# Rezoning Transportation Analysis

Petition Number: 2019-037

Date	Description
04-10-19	First Review (Joe Mangum)
07-27-20	Second Review (EL)
10/15/20	Third Review (KP)

**SITE PLAN**

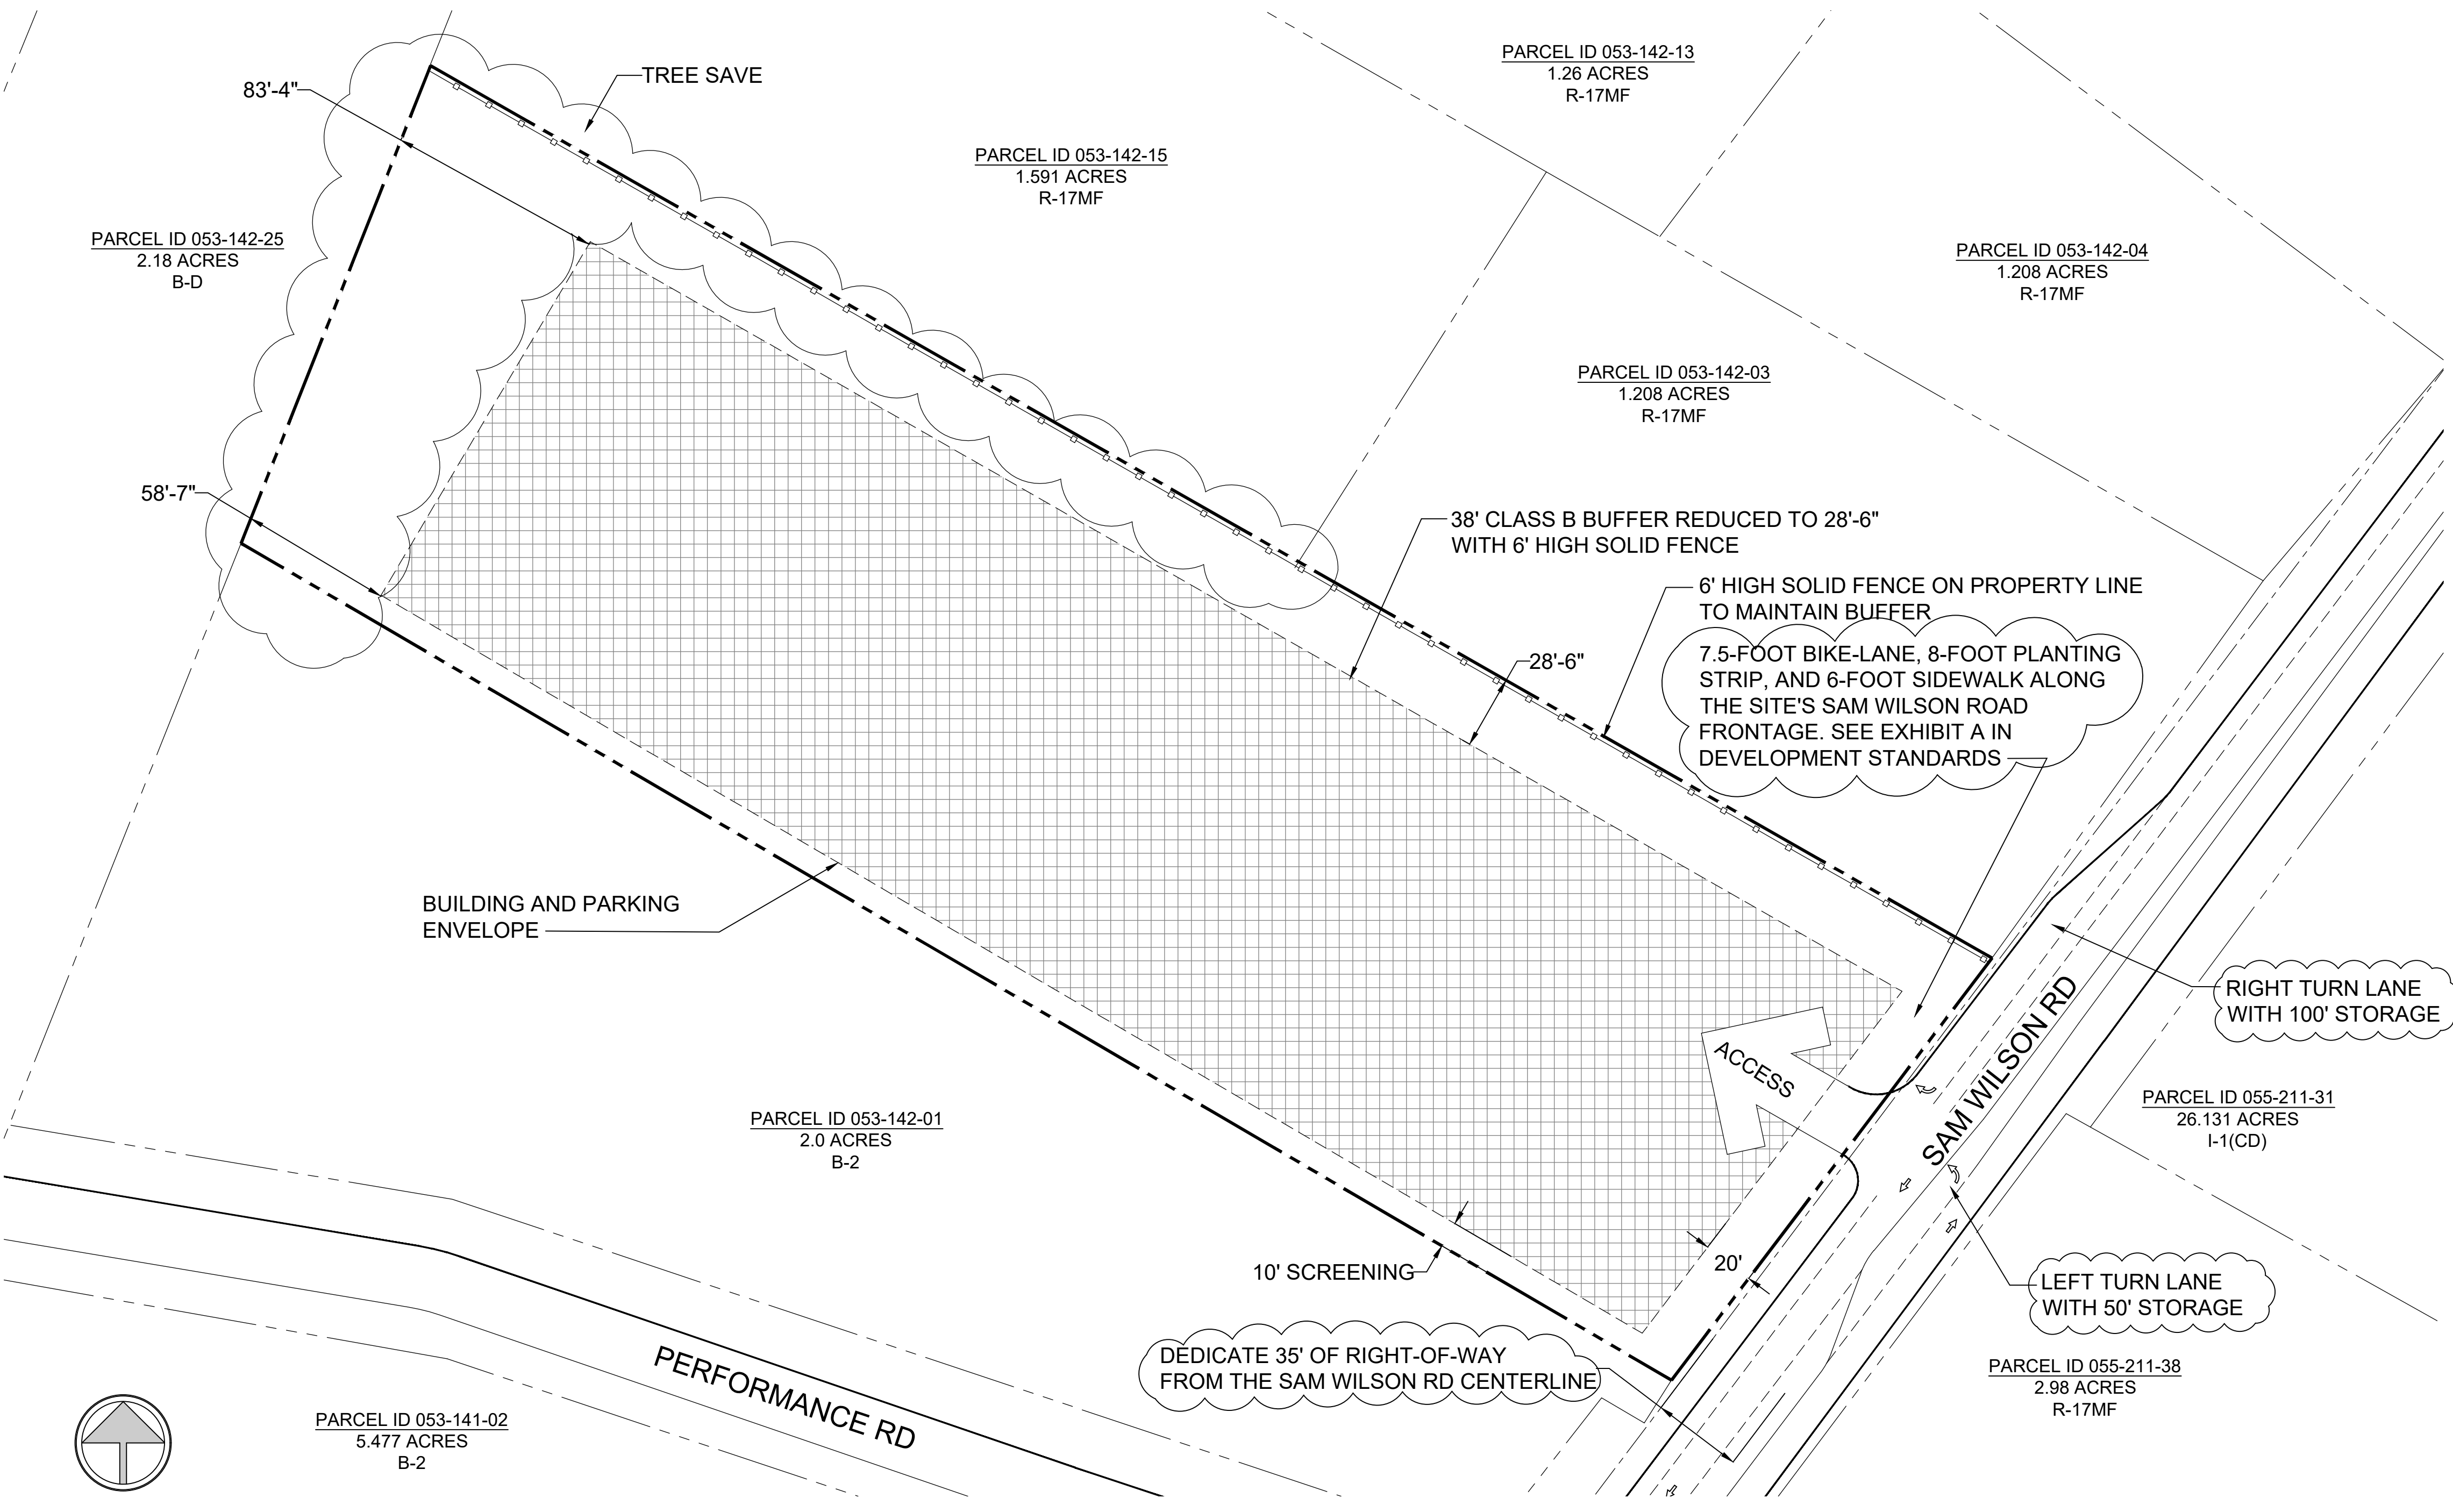
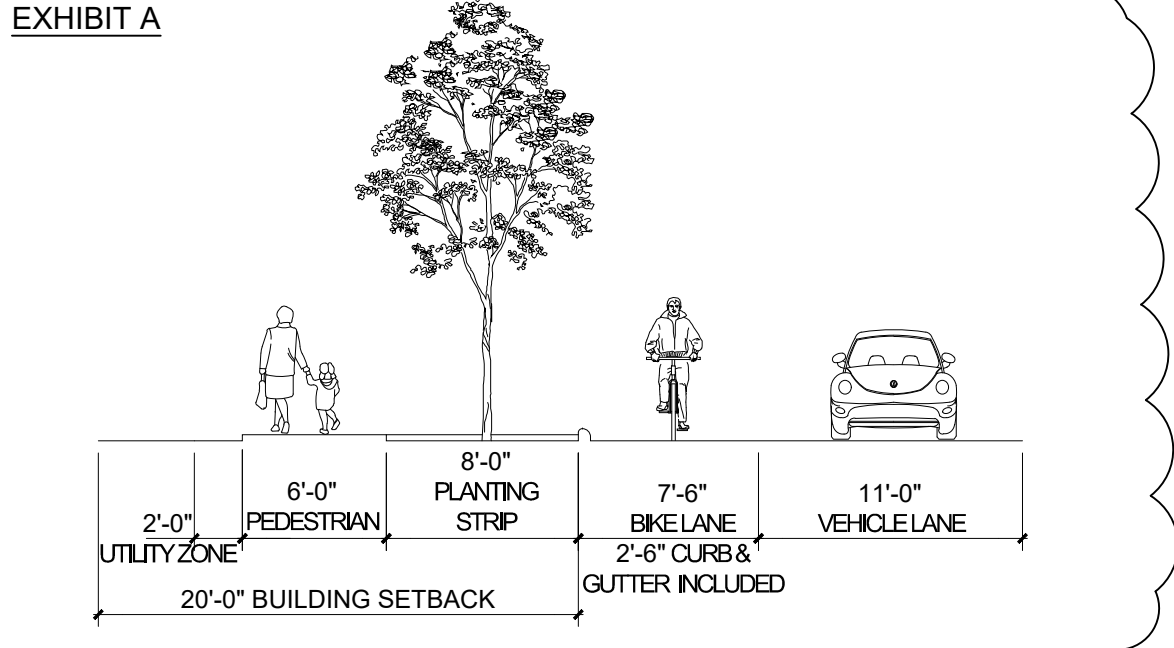
- Revise the site plan and conditional note(s) to commit to dedicate 35-feet of right-of-way from the Sam Wilson Road centerline; the right-of-way from the road centerline needs to be labeled and dimensioned on the site plan.

- Revise site plan and conditional note(s) to commit to construct an 8-foot planting strip and 6-foot sidewalk along Sam Wilson Road per Chapter 19 of the City Code; label and dimension both items from the back of curb and gutter and road centerline.

- Revise the site plan and conditional note(s) to include the construction of the cross section, as noted in the Catawba Area Plan, along the site's frontage on Sam Wilson Road. The bike lane, back-of-curb, planting strip, and sidewalk need to be labeled and dimensioned from the center line of Sam Wilson Road.

8. **New Comment from 10/09/2020 submittal:** As a result of the proposed use(s) changing and the relative square footage, a TIS is no longer required. However, the petitioner and NCDOT have agreed to additional transportation improvements in-leu of the TIS. The site plan will be revised to show these improvements, and these improvements will be included in the conditional notes. The improvements are as follows:

- a. A left-turn lane, into the site, with a 50-foot taper between the site's left-turn lane and the southbound left-turn lane to turn onto West Pointe Drive.

- b. A right-turn lane into the site with 100-feet of storage and an appropriate taper.
  - c. Provide a \$25,000 contribution to NCDOT for the future traffic signal at Sam Wilson Rd. and Performance Rd./West Pointe Dr.
